From: Jennifer Thompson
To: Fraser, Jean
Date: 1/23/2014 7:45 AM
Subject: 118 Congress Street - Plat and Condo Docs

Jean - I agree with your assessment. The Plat and the condo docs for this application are marginal. Although I realize that the practice has, somewhat by necessity, been to make final edits to the plat and condo docs a condition of approval, there is still a requirement that applications for subdivision approval be complete when they go before the Board and that the proposed plat and condo docs contain sufficient detail to allow the Board to make an informed decision. As you say, for this one the plat and condo docs need to be clear with respect to:

SUBDIVISION RECORDING PLAT
C1.0

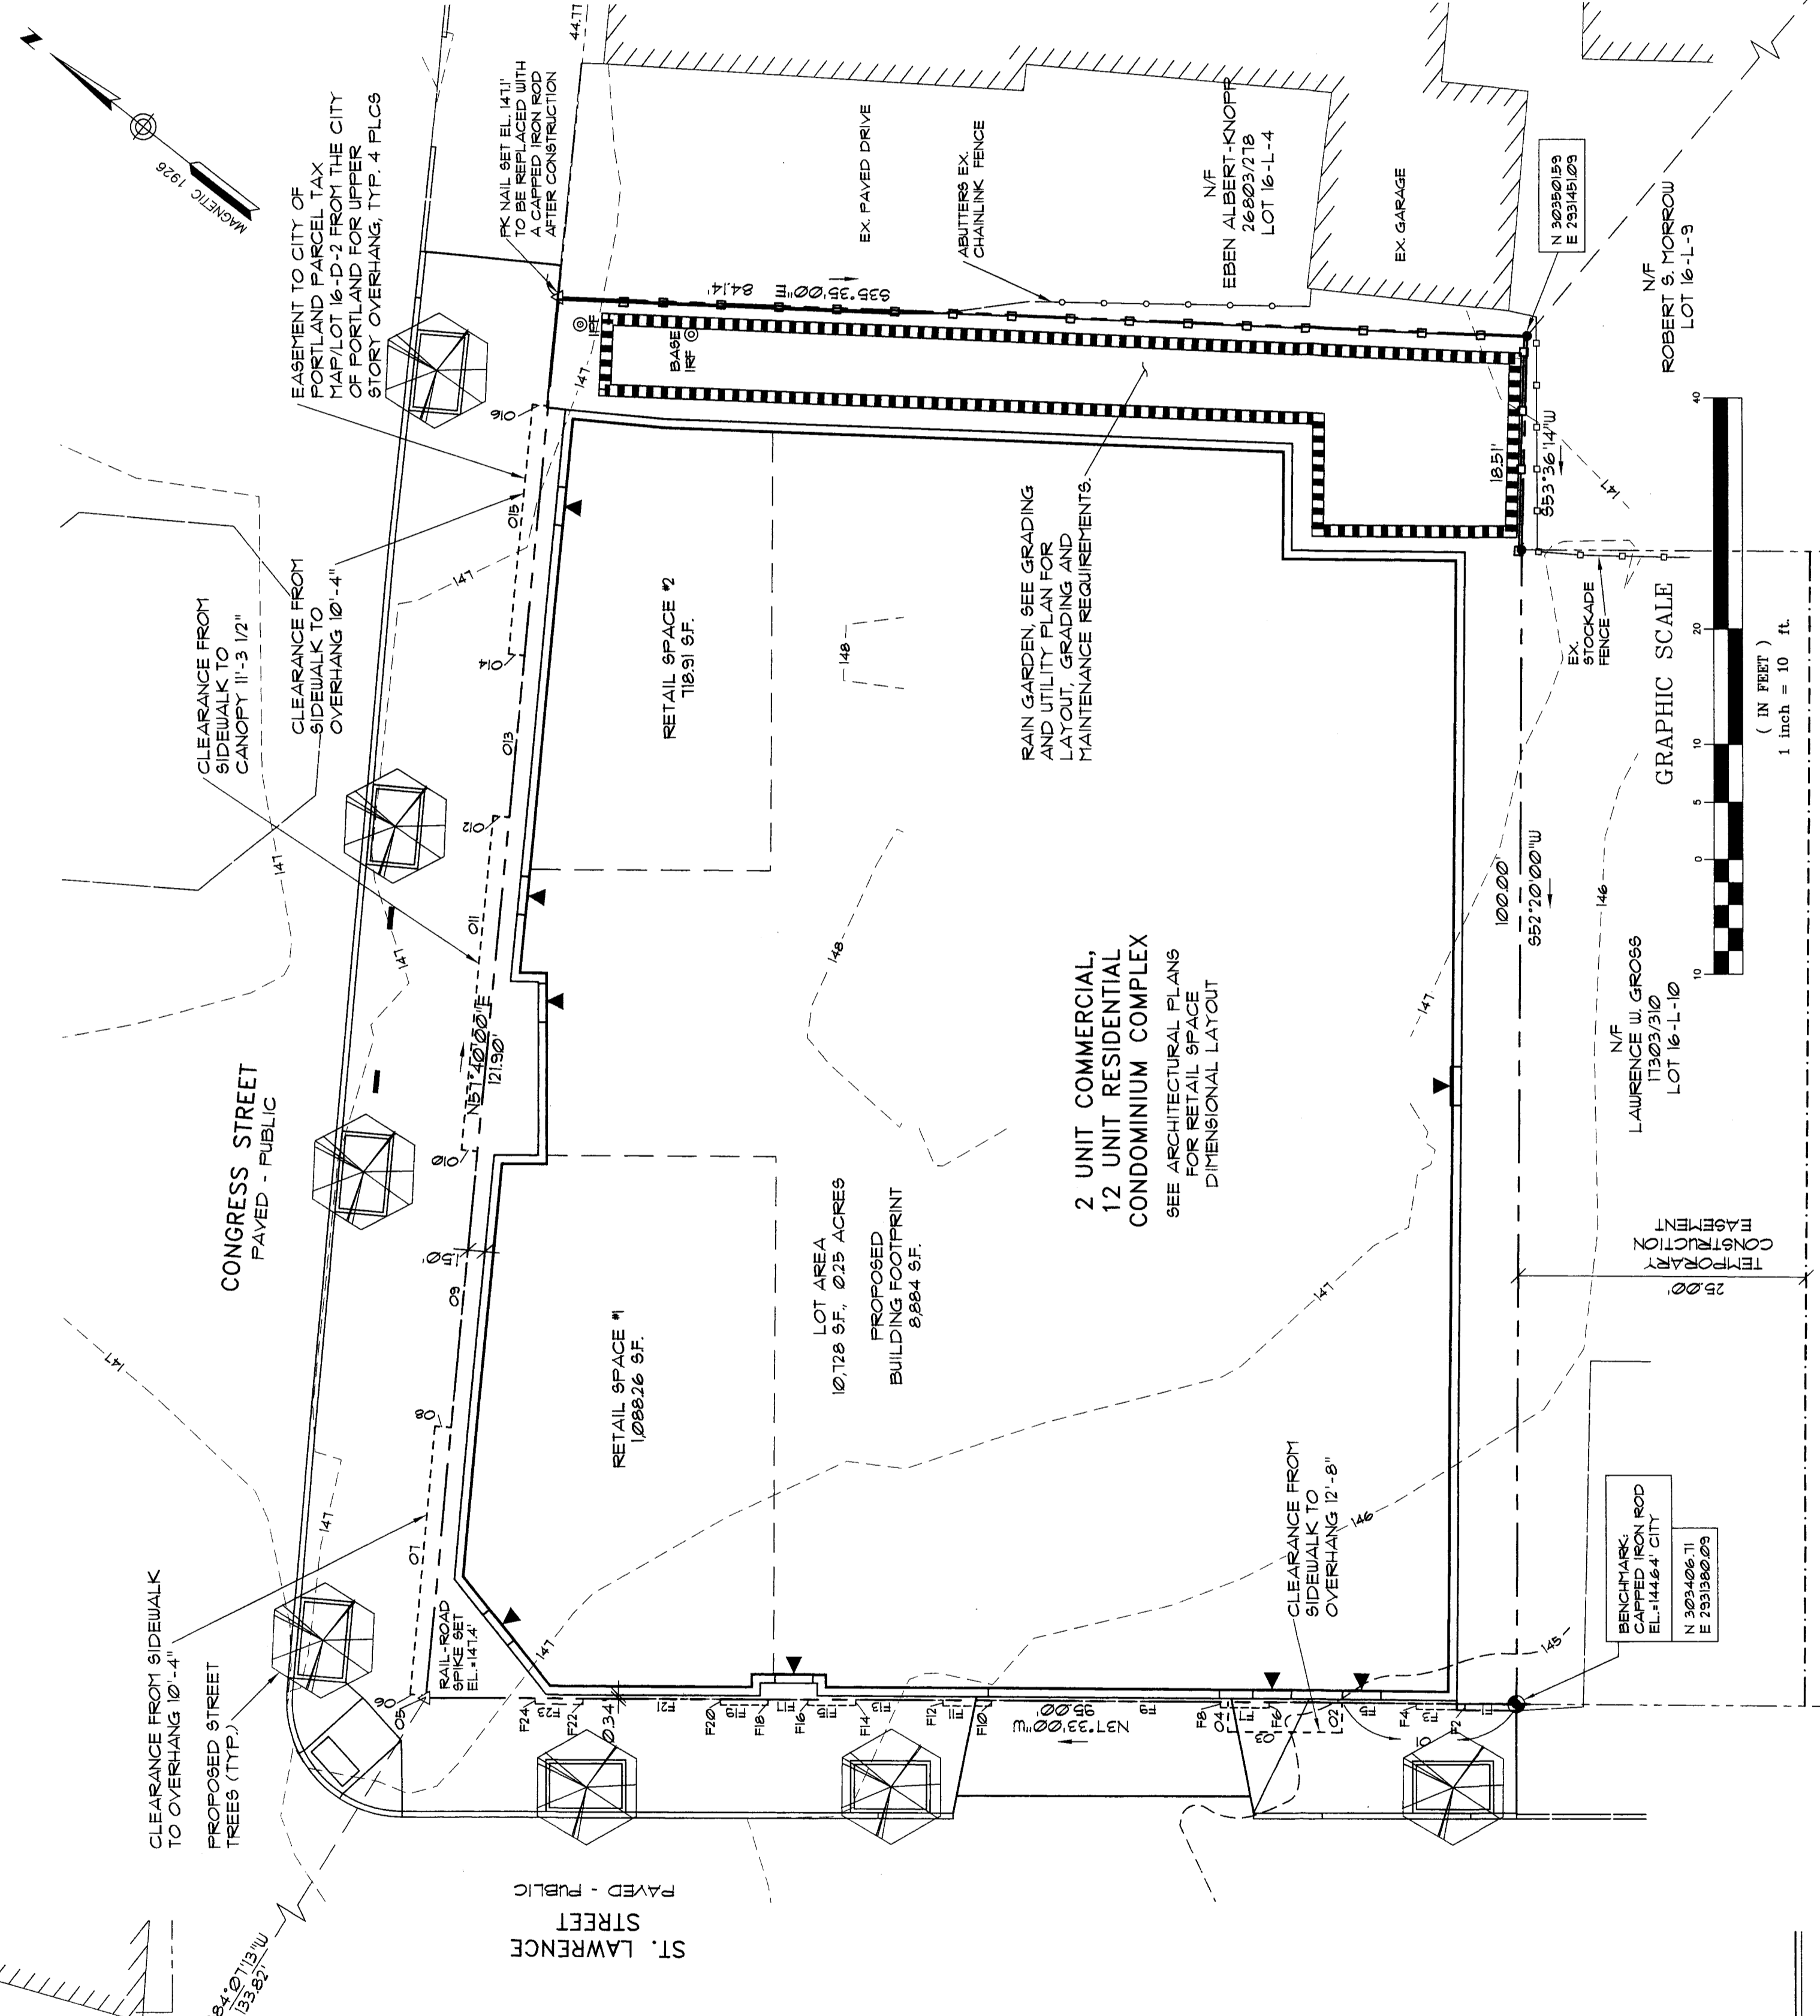
- Existence of the parking level and number of spaces and access
- Sq footage of commercial units and at least the aggregate square footage of residential
- Location of street trees
- location of raingarden (abutting Eben ALbert-Knoff property line) and ref stormwater system maintenance (confirming that this is not city and referring to agreement etc)
- more detail re overhangs over ROW
- Show all nearby buildings on plat
- Maintenance of green walls on side and rear elevations
- Existing and anticipated utilities and any associated easements
- Responsibility for general maintenance and trash and snow removal

The subdivision plat really needs to inform folks of necessary information on its face. It is not sufficient to be incorporating by reference other sheets when it comes to the essential contents of the plat. As with all applications, I direct these folks to our ordinance, which outlines what is required on all plats. Their attorney should similarly be familiar with the State statute that outlines necessary components of condominium documents.
